25 February 2013

File No: R/2013/4
Our Ref: 2012/059740
Your Ref: SSD 5087-2011

RE: Australian Institute of Nanoscience (AIN) Building, The University of Sydney (SSD 5087-2011)

3 West Link Elevation 1
SCALE: 1 : 50

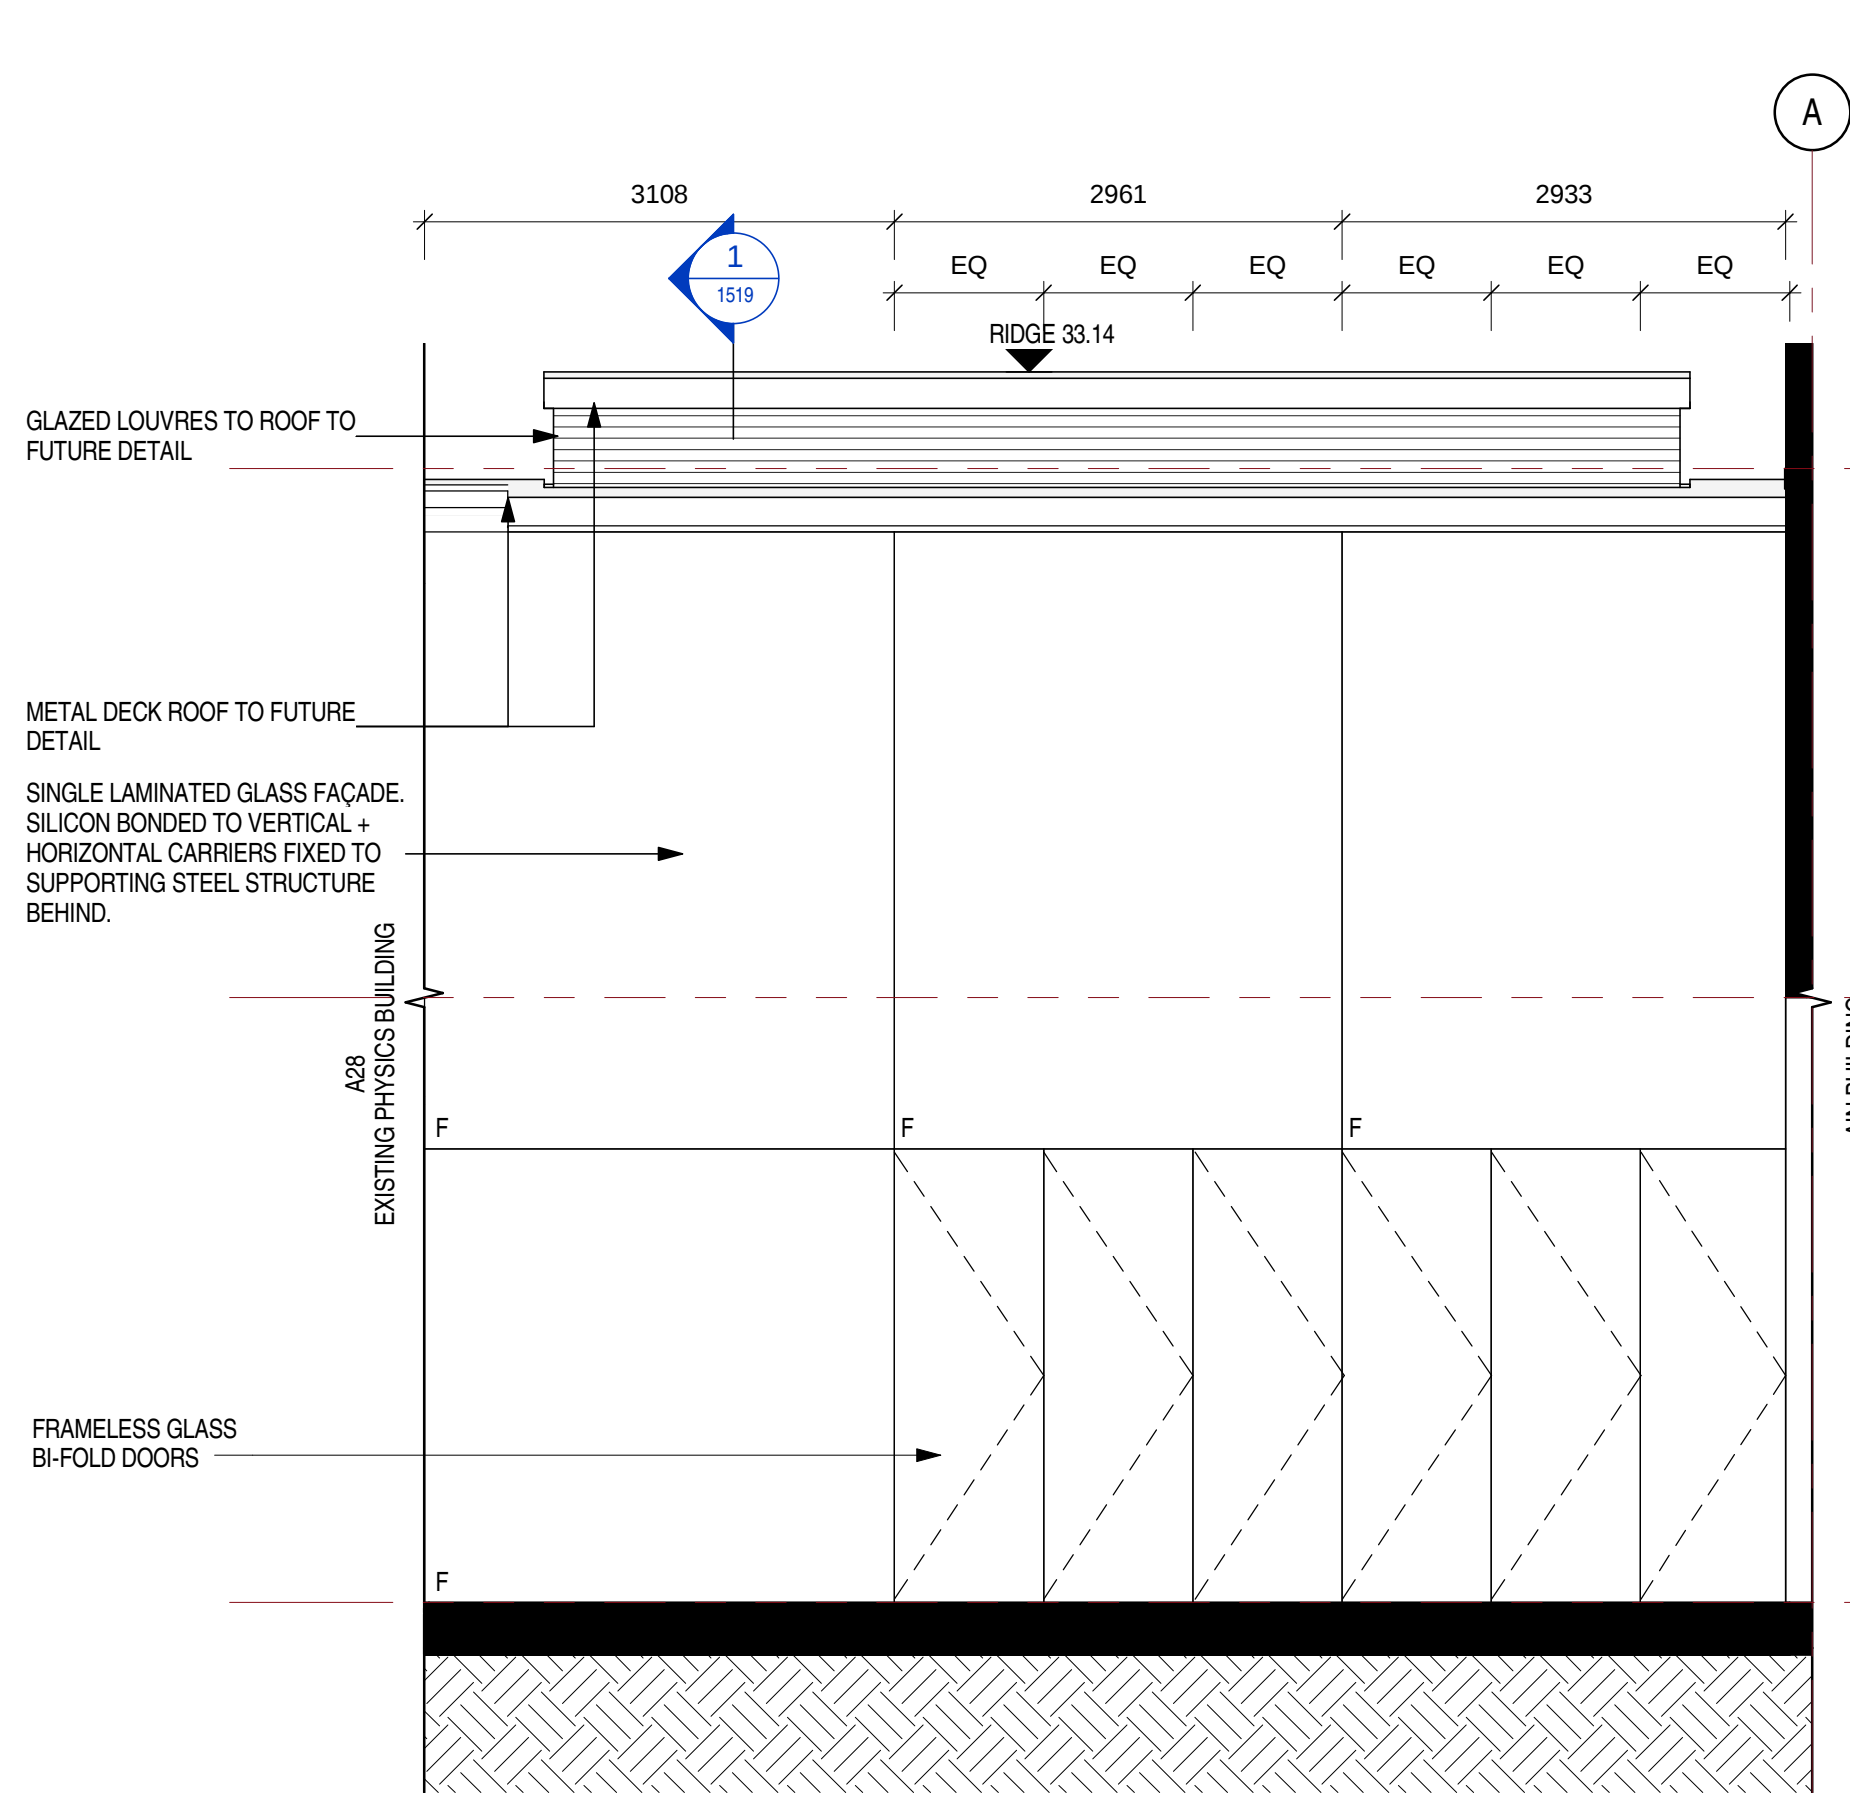
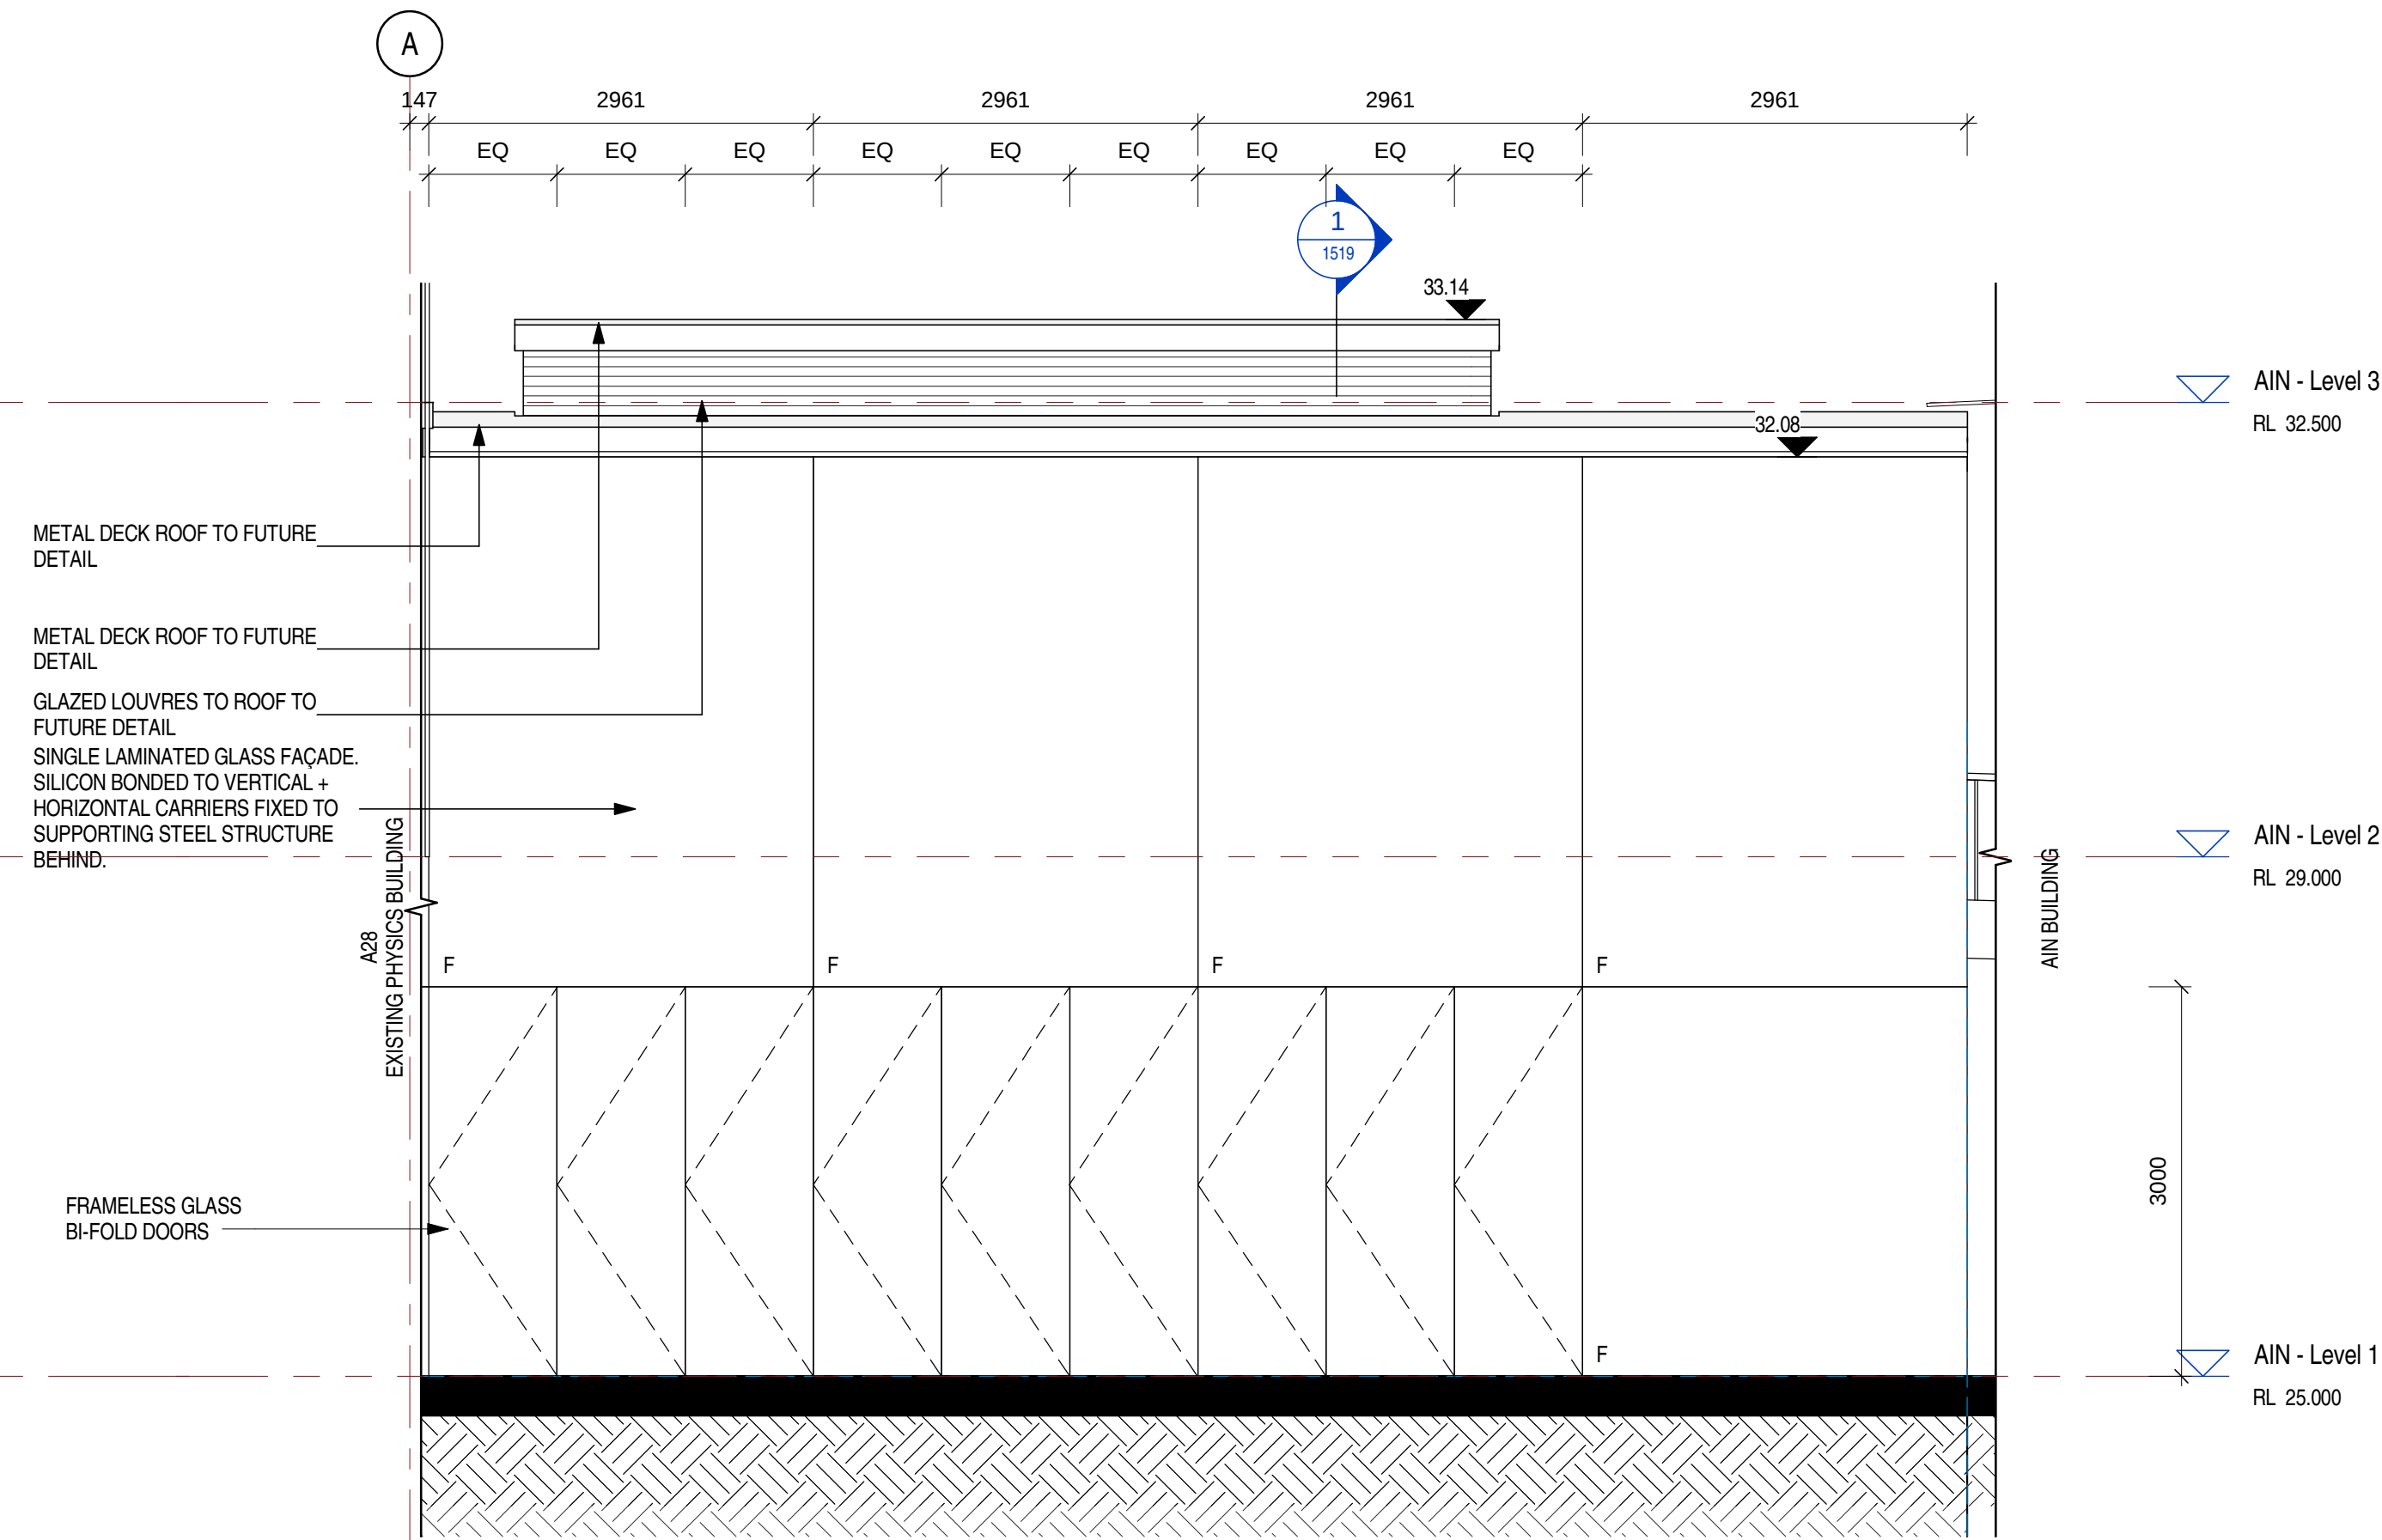
- The proposed new buildings at St Paul's College will largely screen the new building from the college oval and grounds.
- The physical impacts on the Physics Building, comprising two new linkages between the buildings and fire separation requirements, are generally acceptable. The links have been designed to retain views to the rear of the Physics Building and create a southern courtyard aligned to the Wilkinson axis. They are unlikely to diminish light levels within the main staircase and the vestibule.

All new internal and external finishes and works of making good to the Physics Building shall match the existing original work adjacent in respect of materials used, detailed execution and finished appearance
